Our ref: DOC21/662085-5

Your ref: SSD-8889679

Liddell Battery and Bayswater Ancillary Works Project (SSD-8889679) – Request for Advice

BCD's detailed comments

Figure 6 - 1 Threatened flora surveys - PCT 1691 (vegetation zones 1, 3, 4)

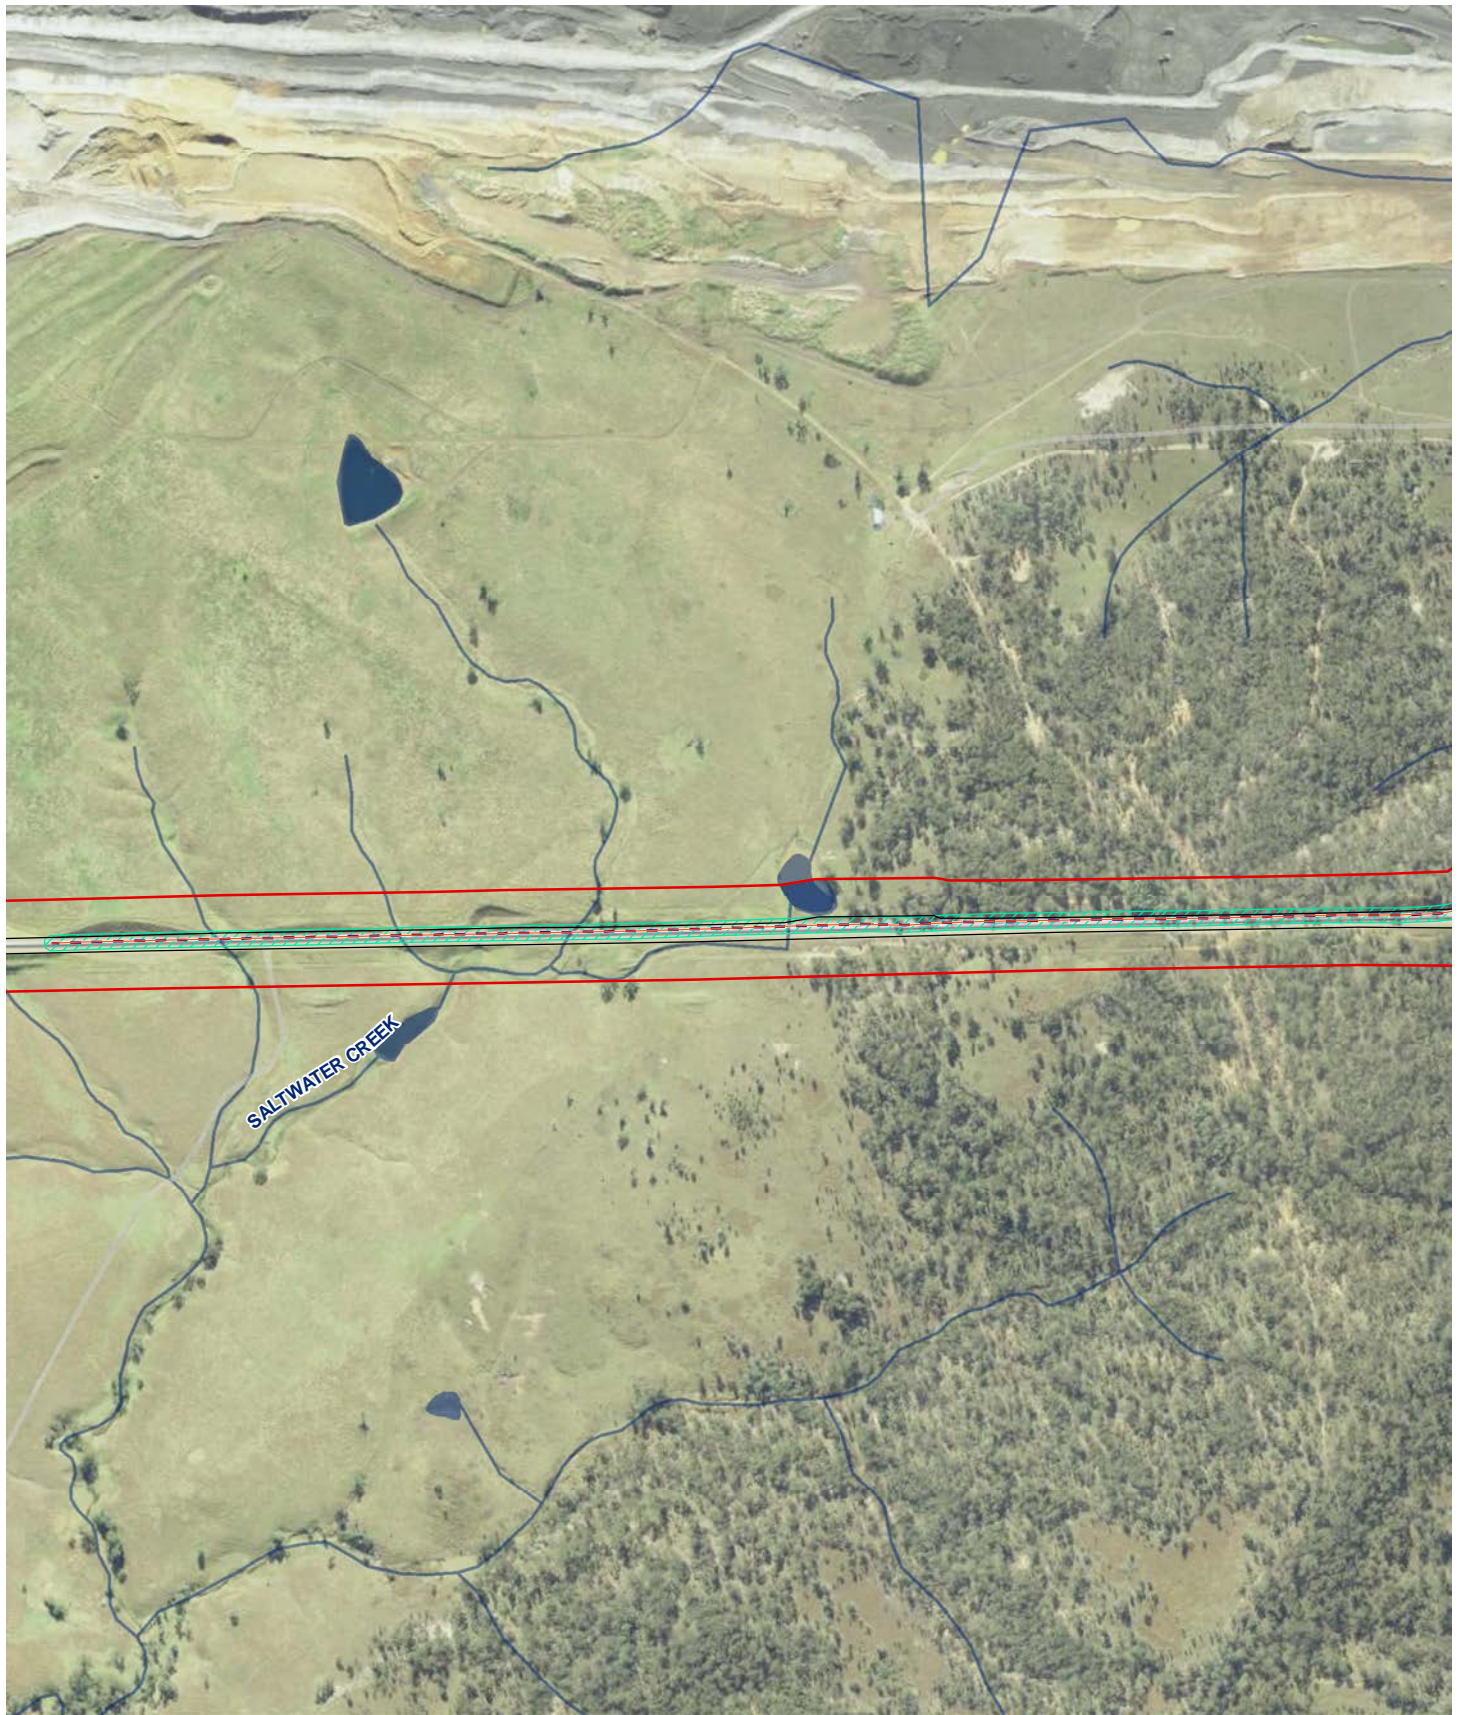
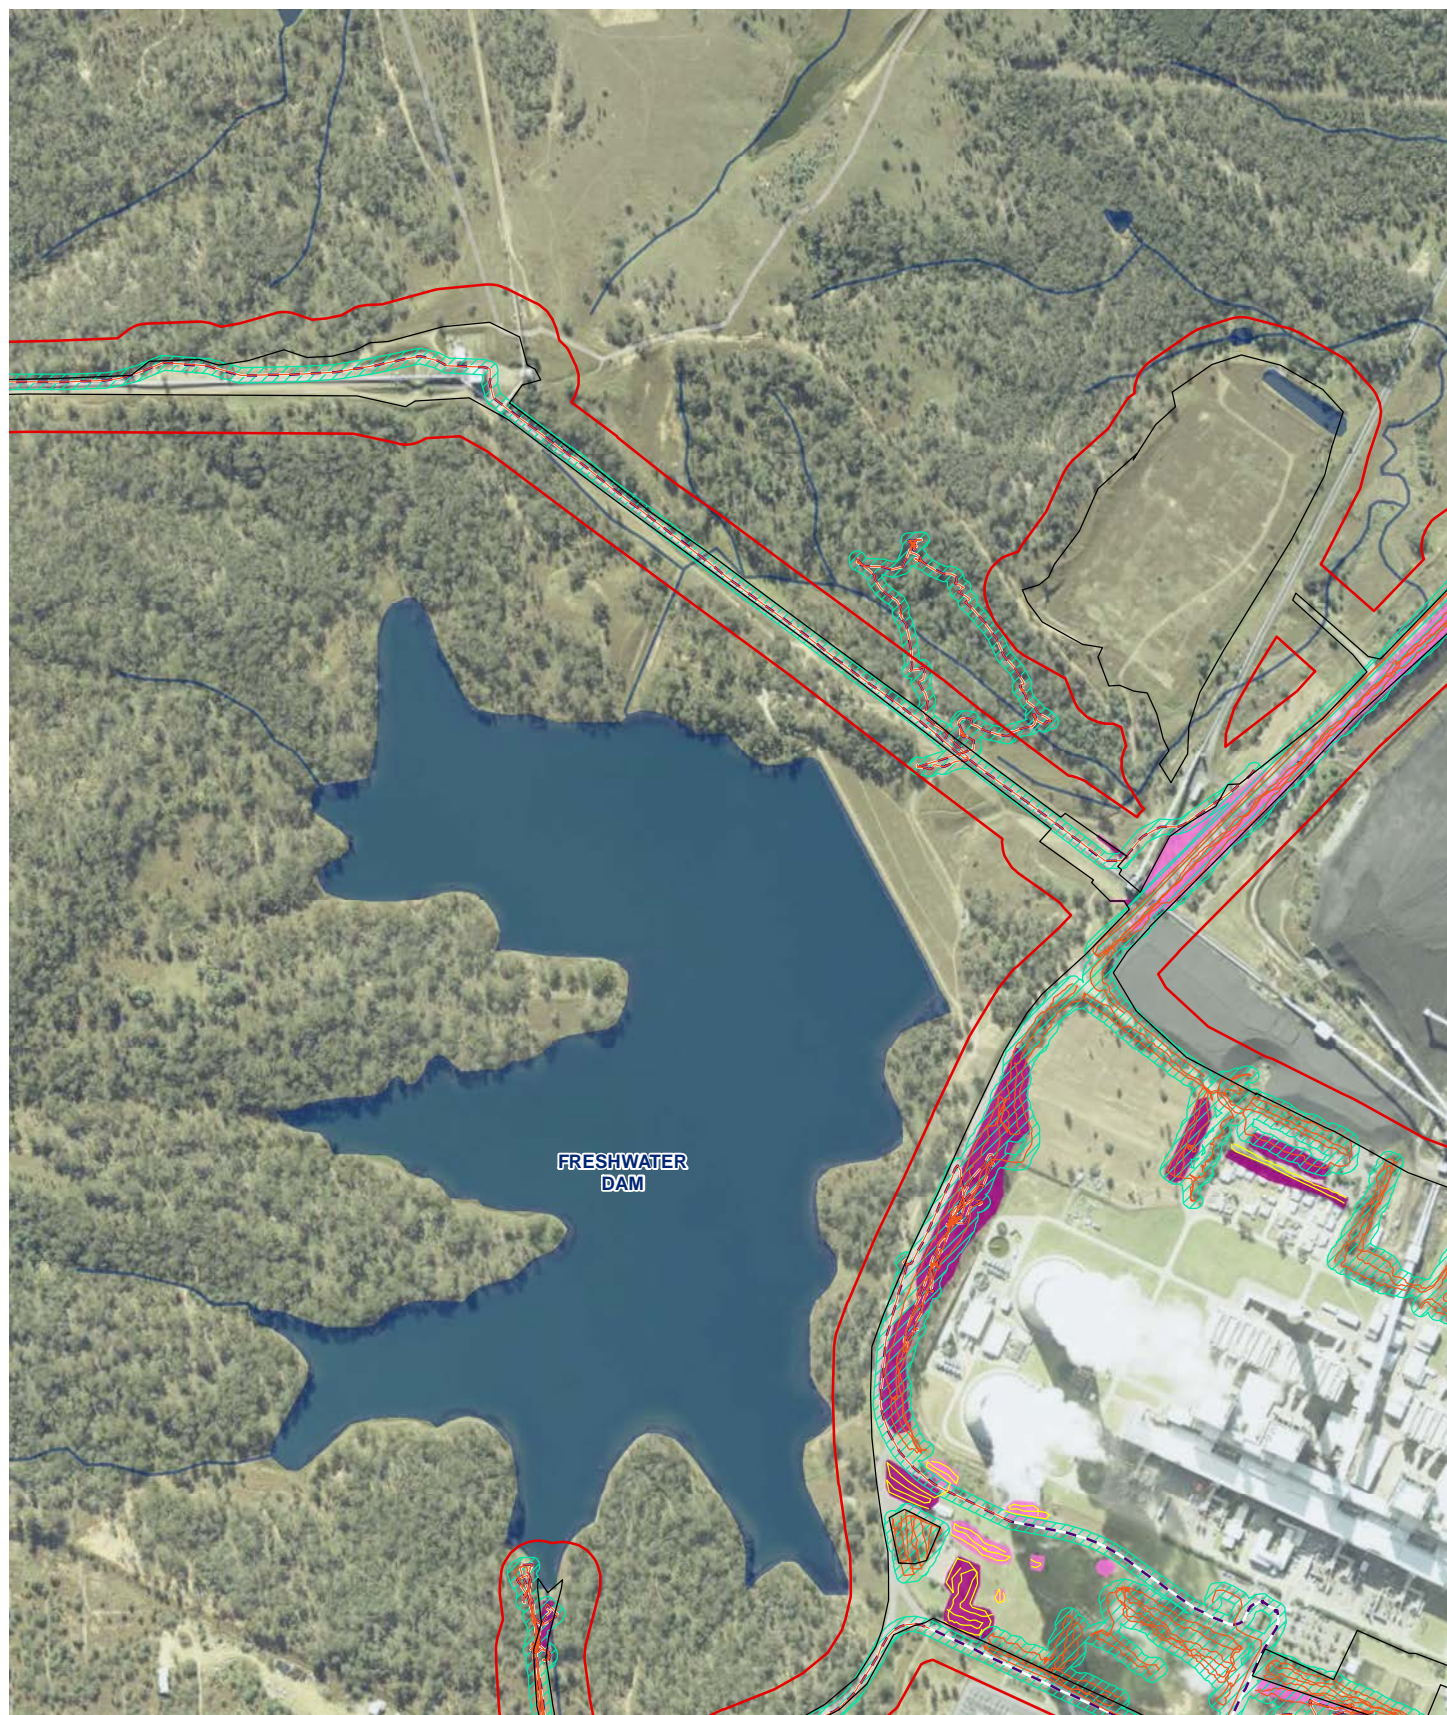
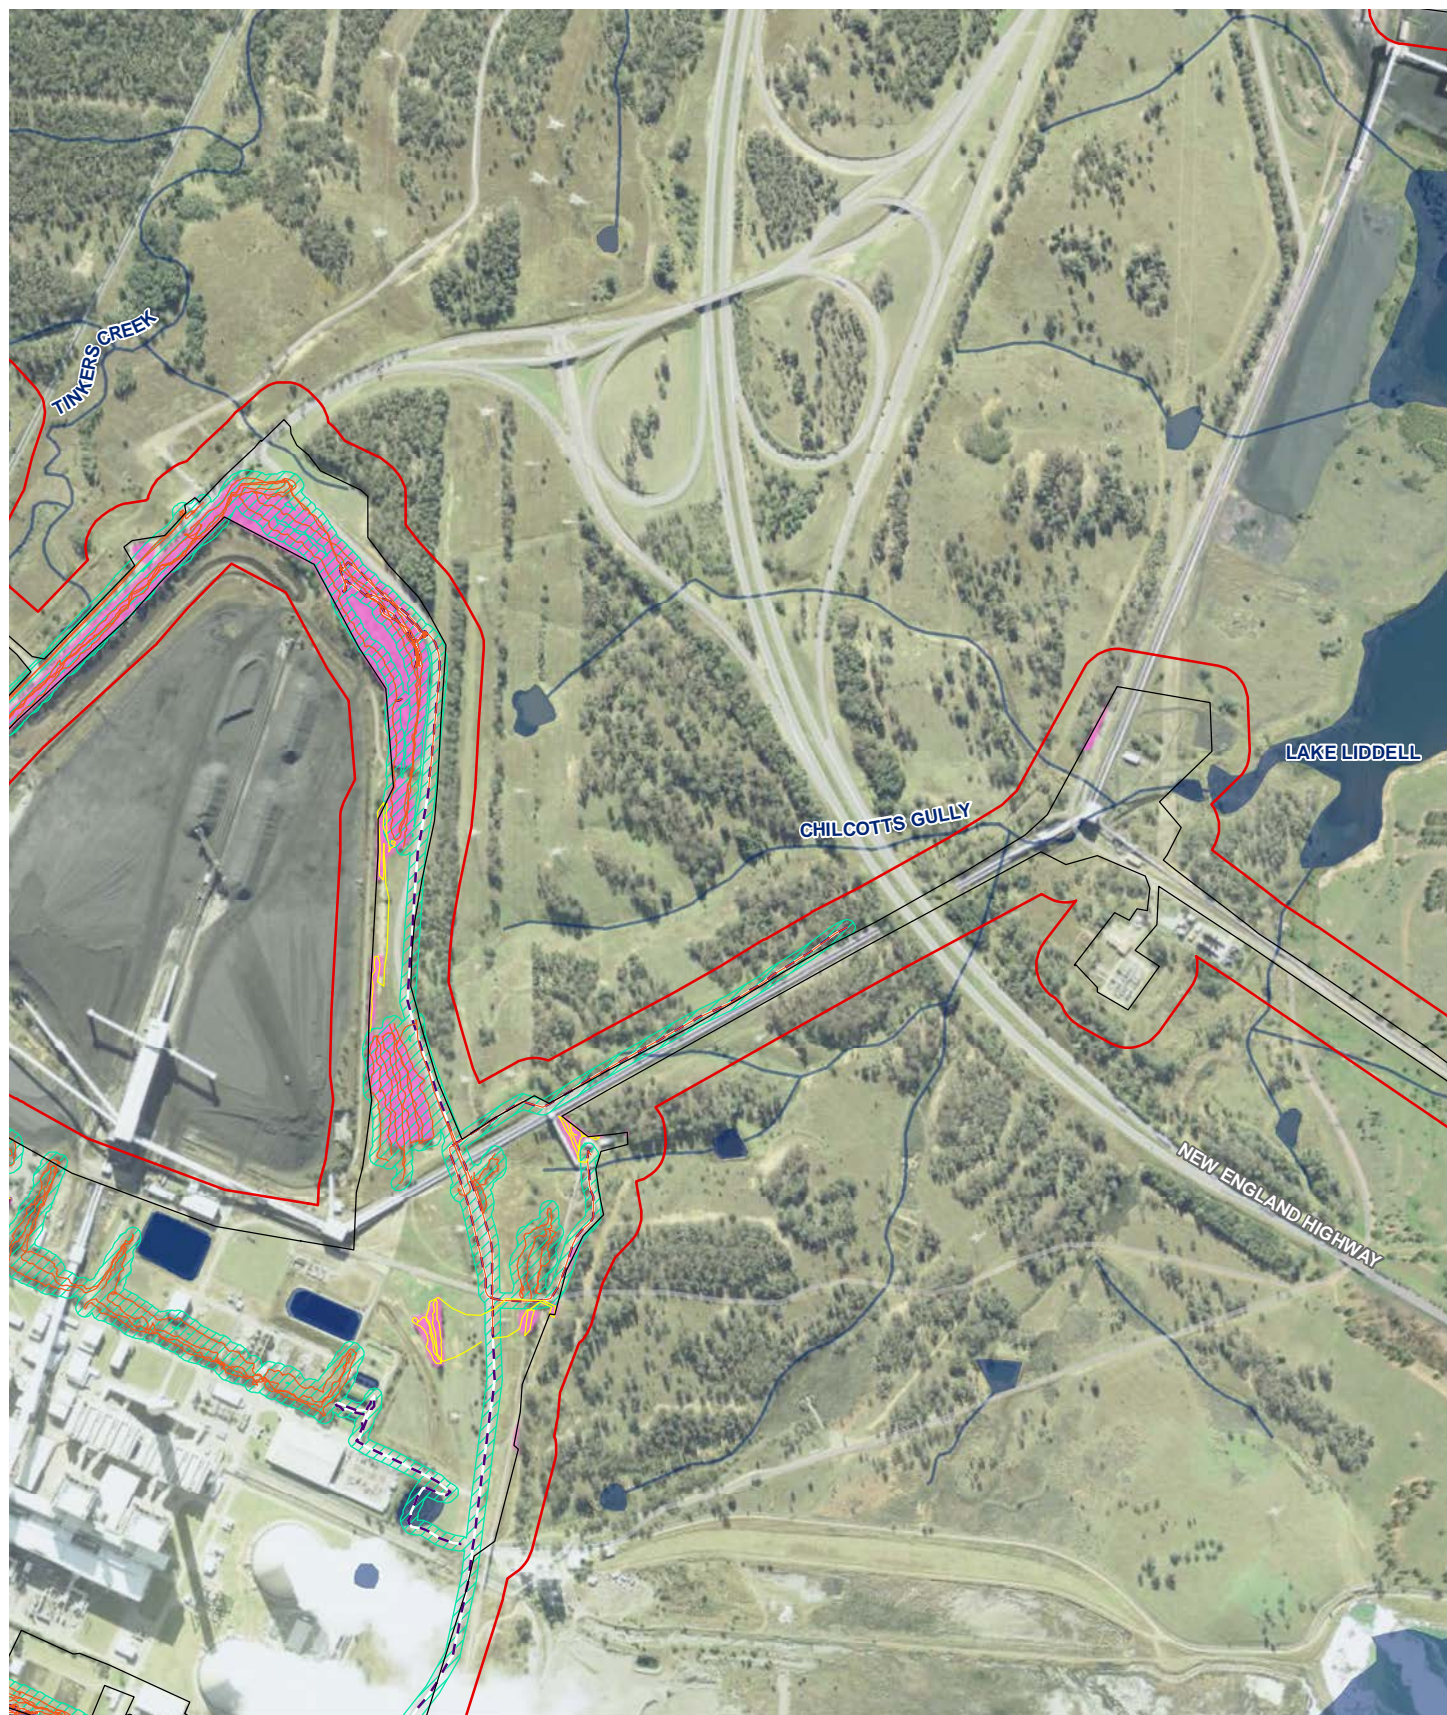
The targeted flora survey tracks shown in Figure 6-1 (pp. 66-80) and provided as shapefiles do not show that targeted flora surveys were conducted in all vegetation zones for PCT 1691 within the development footprint. This is apparent on pages 68-70, 75-76, 78 and 80.

This PCT is associated with threatened orchids *Pterostylis chaetophora* and Tarengo Leek Orchid (*Prasophyllum petium*) as well as Tall Knotweed (*Persicaria elatior*). Targeted flora searches should be conducted for these species in all vegetation zones for PCT 1691 in accordance with the requirements detailed in Section 4.2 of the *Surveying threatened plants and their habitats - NSW survey guide for the Biodiversity Assessment Method*.

BCD recommends that effort for targeted flora searches is demonstrated in all vegetation zones for Plant Community Type 1691 within the development footprint.
